Development Review Checklist

Level I / **Level II** / Level III / Master Plan
 Project Name: Luminato
 Address: 169 Newbury Street
 Description: Alteration / Addition / **New Construction**
 Date Received: 1/26/16 **Prelim** / Final
 Planner: Caitlin Cameron

A2.1

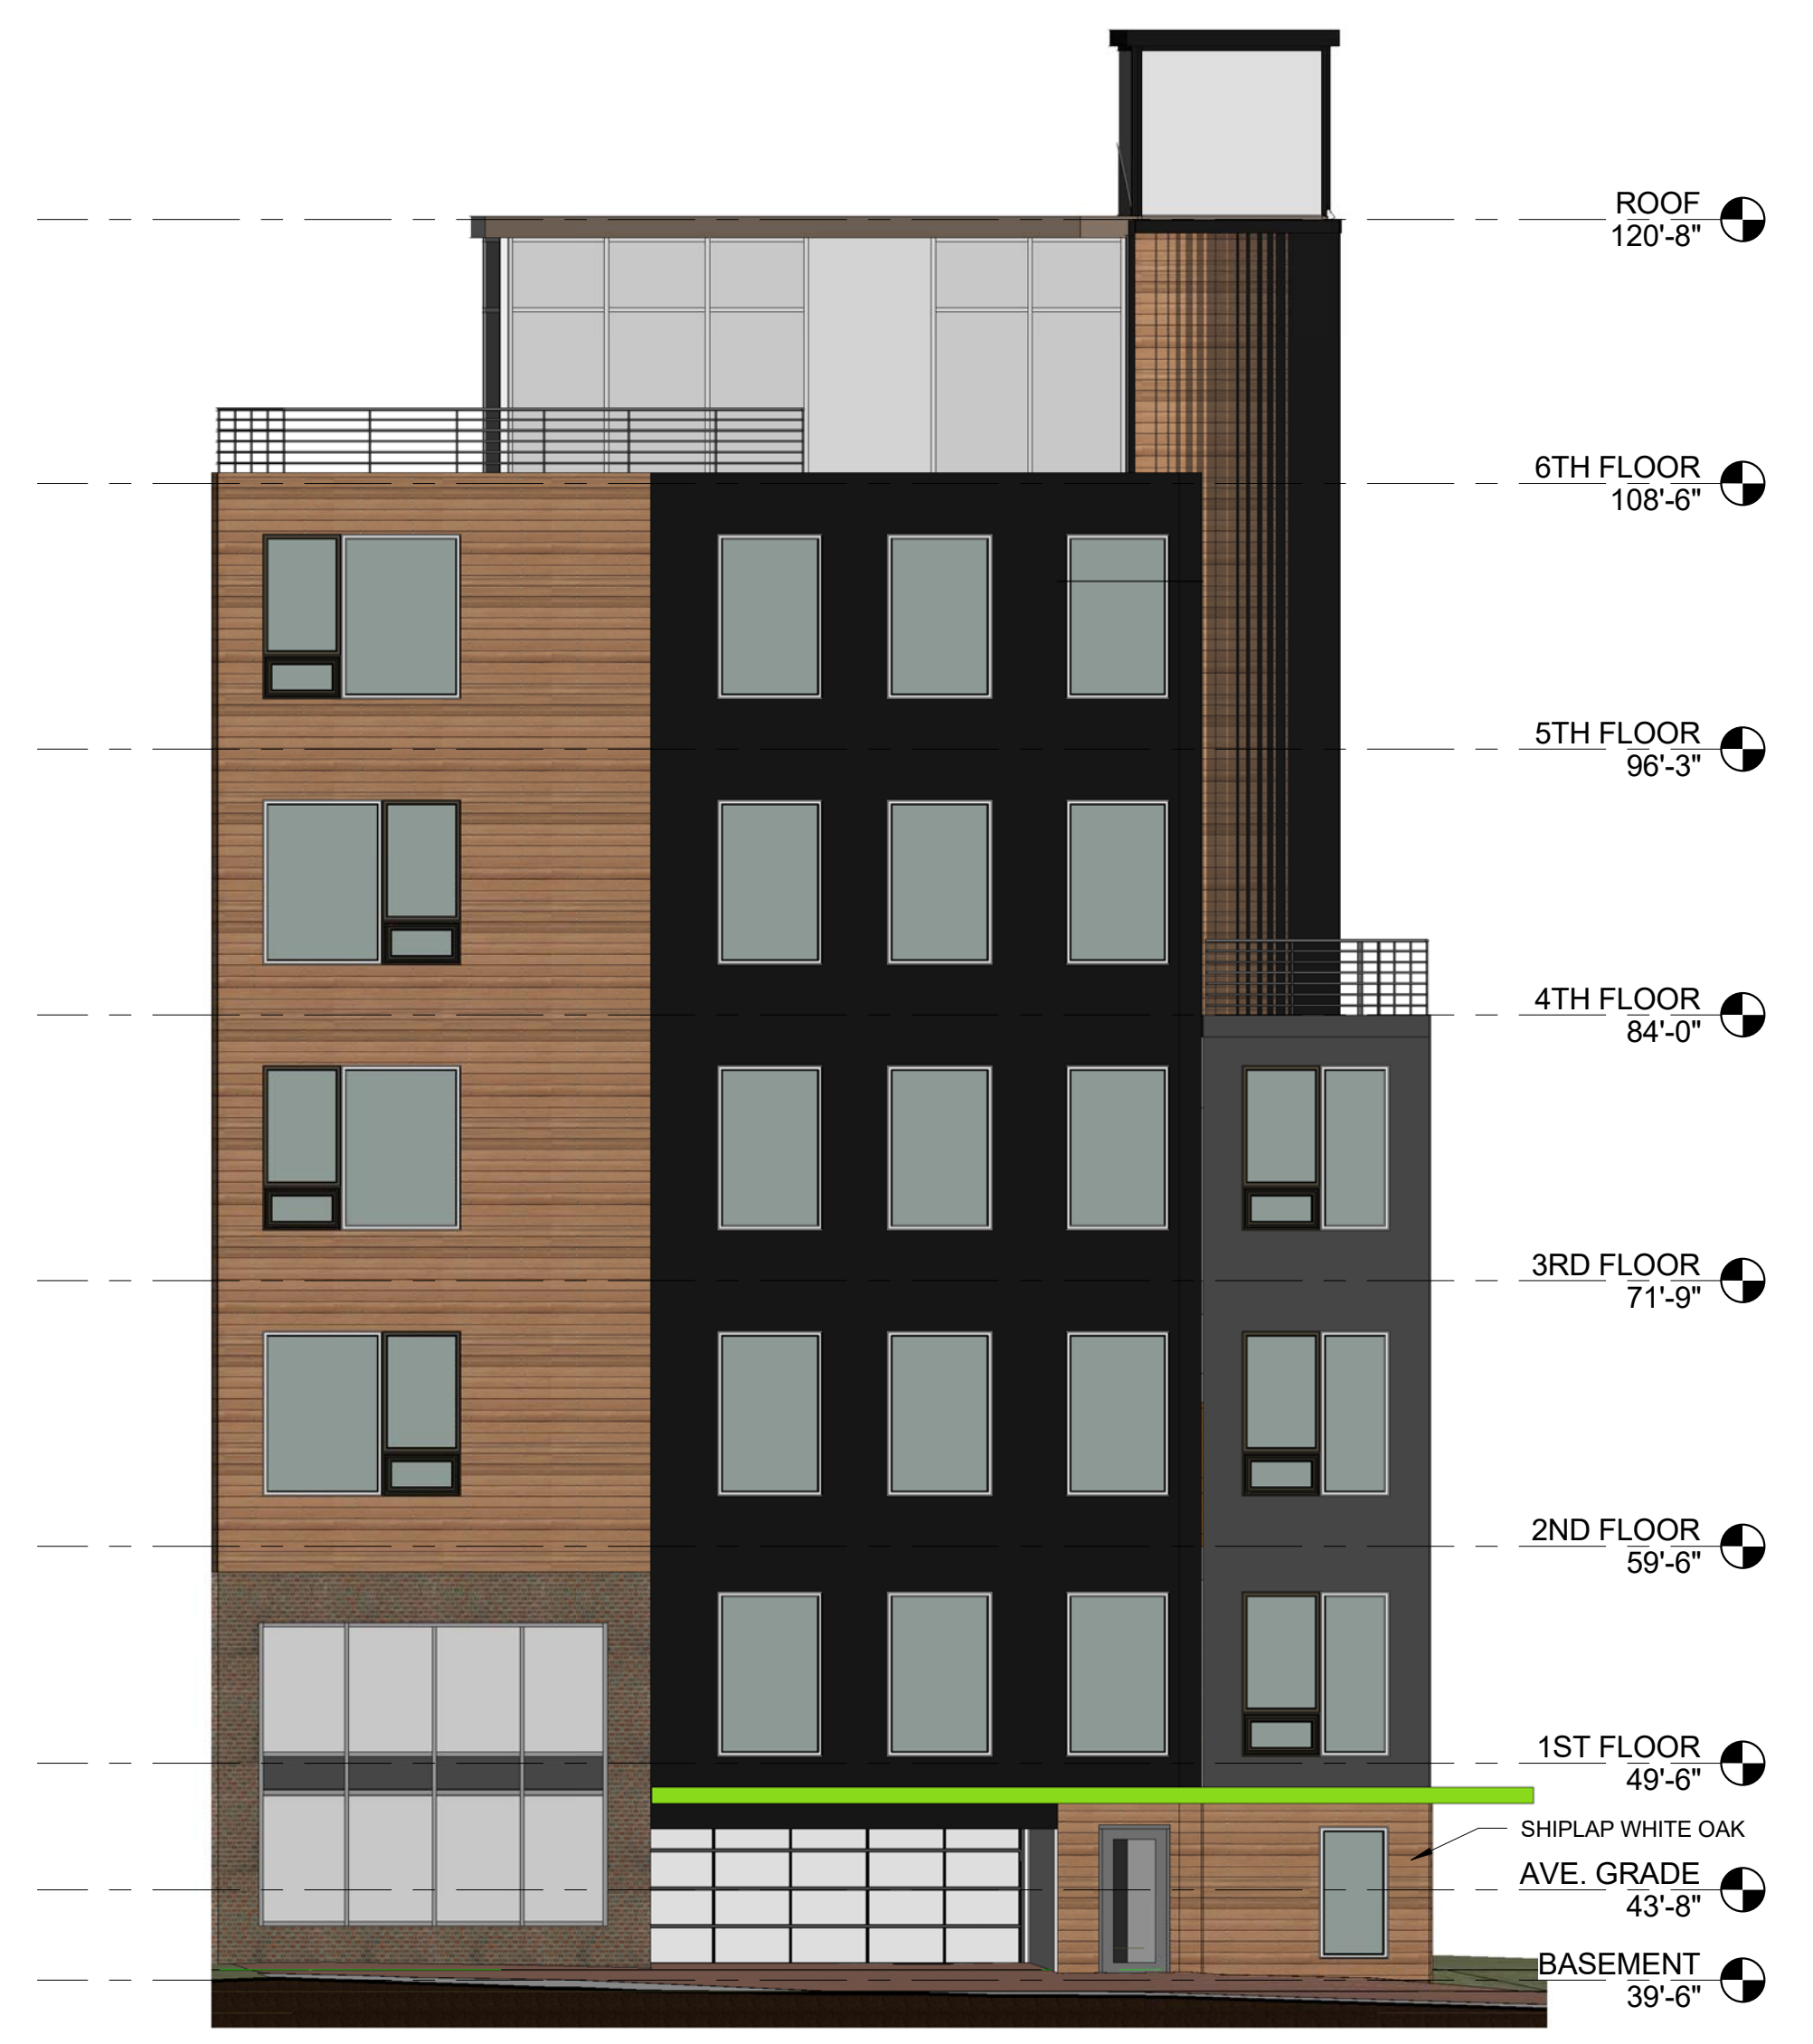
Rear Yard	<input type="checkbox"/>	<input type="checkbox"/>	<input type="checkbox"/>	<input checked="" type="checkbox"/>	
	Complies	More Info	Does Not Comply	N/A	Comments
Building Entries					
Frequency	<input type="checkbox"/>	<input type="checkbox"/>	<input checked="" type="checkbox"/>	<input type="checkbox"/>	No entry provided on Franklin façade – at least one is required Sec. 14-275.7 UT
Principal Entry Orientation	<input checked="" type="checkbox"/>	<input type="checkbox"/>	<input type="checkbox"/>	<input type="checkbox"/>	Principle entry on Newbury
Principal Entry Elevation	<input checked="" type="checkbox"/>	<input type="checkbox"/>	<input type="checkbox"/>	<input type="checkbox"/>	At grade
Height Standards					
Principal Building					
Height	<input checked="" type="checkbox"/>	<input type="checkbox"/>	<input type="checkbox"/>	<input type="checkbox"/>	Under 65'; more info requested for bonus

Stories	<input type="checkbox"/>	<input checked="" type="checkbox"/>	<input type="checkbox"/>	<input type="checkbox"/>	See above: Green roof information needed to confirm height bonus eligibility
Stepbacks (UT, bonus)	<input type="checkbox"/>	<input checked="" type="checkbox"/>	<input checked="" type="checkbox"/>	<input type="checkbox"/>	MIR: dimension stepbacks on plan/elevation Please explain why stepback requirement is not applied to full length of building adjacent to UN properties. See drawing markup.
Accessory Building(s)	<input type="checkbox"/>	<input type="checkbox"/>	<input type="checkbox"/>	<input checked="" type="checkbox"/>	
Parking Standards					
Surface Parking Location	<input type="checkbox"/>	<input checked="" type="checkbox"/>	<input type="checkbox"/>	<input type="checkbox"/>	MIR: dimension showing surface parking space is at least 35' from street-facing property line
Garage Door Setback	<input checked="" type="checkbox"/>	<input type="checkbox"/>	<input type="checkbox"/>	<input type="checkbox"/>	1 st lot layer determined by façade plane, door is setback from building façade

**8 | GREEN ROOF DETAIL AT 6TH FLOOR DECK**  
 1 1/2" = 1'-0"

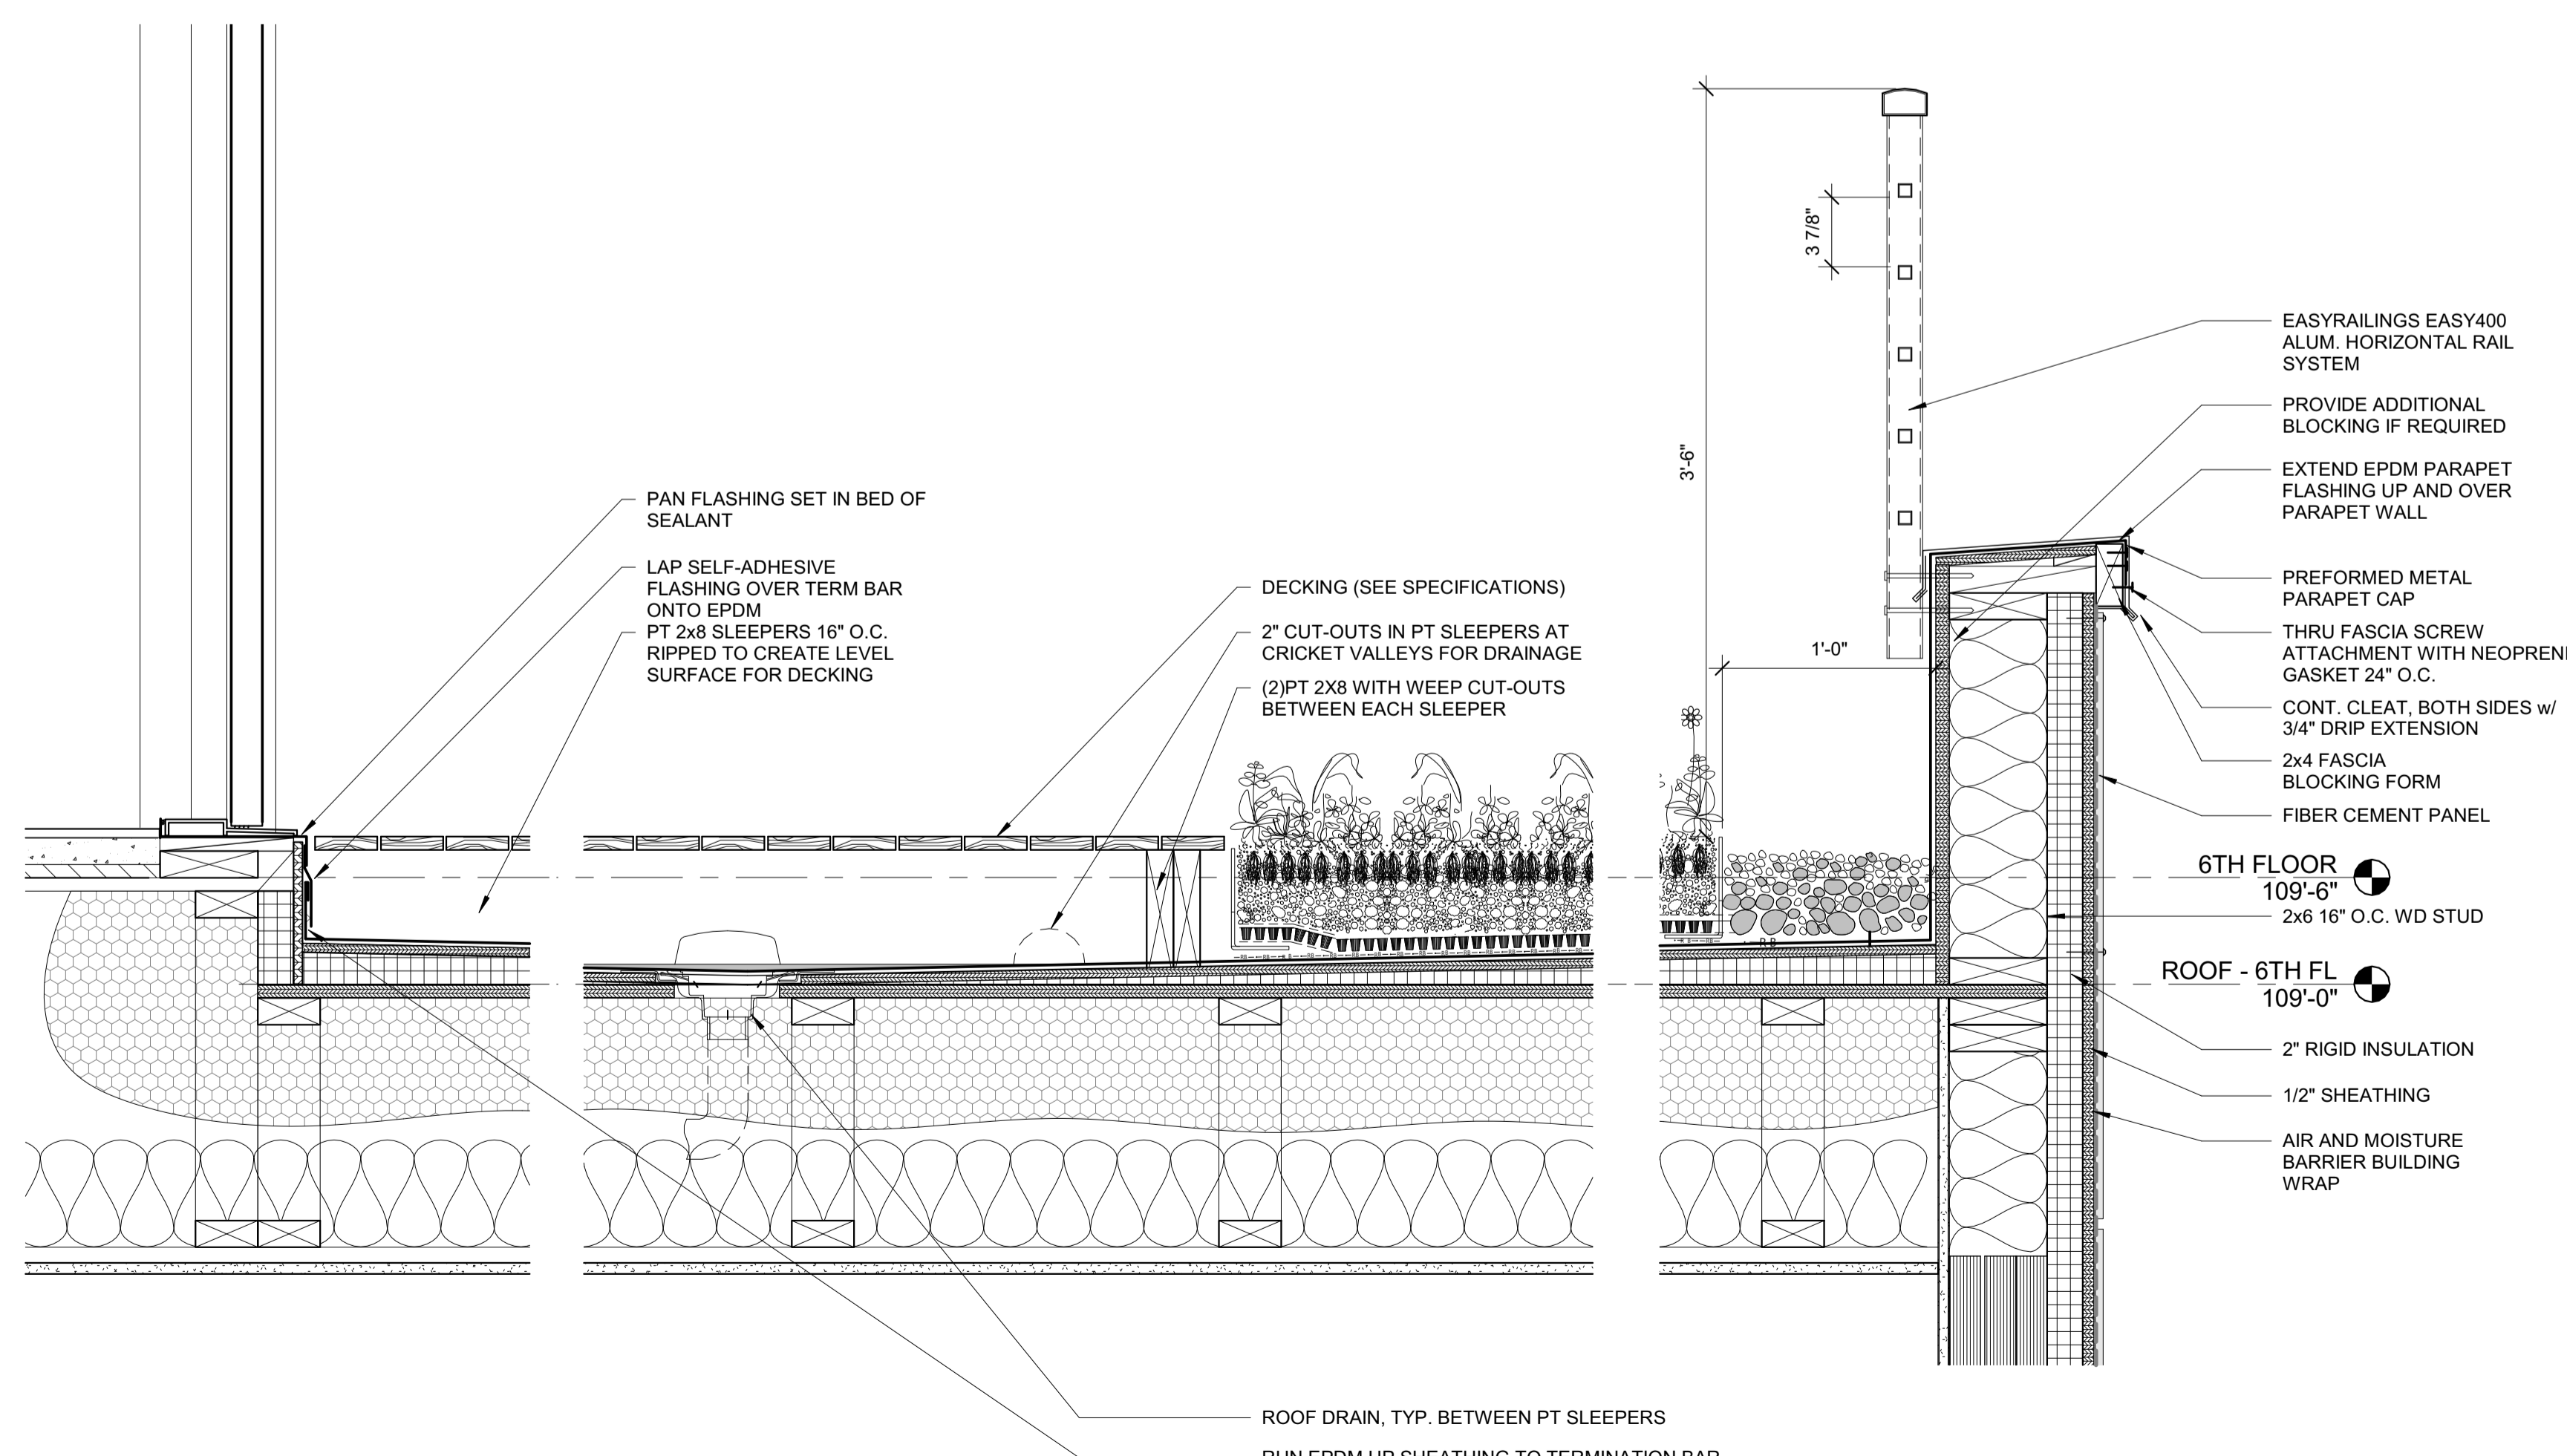
Complies	More Info	Does Not Comply	N/A	Comments
(c) Height Standards					
Height Bonus - Eligible?	<input checked="" type="checkbox"/>	<input type="checkbox"/>	<input type="checkbox"/>	<input type="checkbox"/>	UT are eligible streets
Height Bonus – Conditions Green Roof+Pervious = 5,135sf 50% roof = 3,228sf	<input type="checkbox"/>	<input checked="" type="checkbox"/>	<input type="checkbox"/>	<input type="checkbox"/>	MIR: green roof details, area calculations that pervious at least 50% site area, dimensions that green roof is 50% of <u>total</u> combined roof area of new construction. See Civil comments for further info.
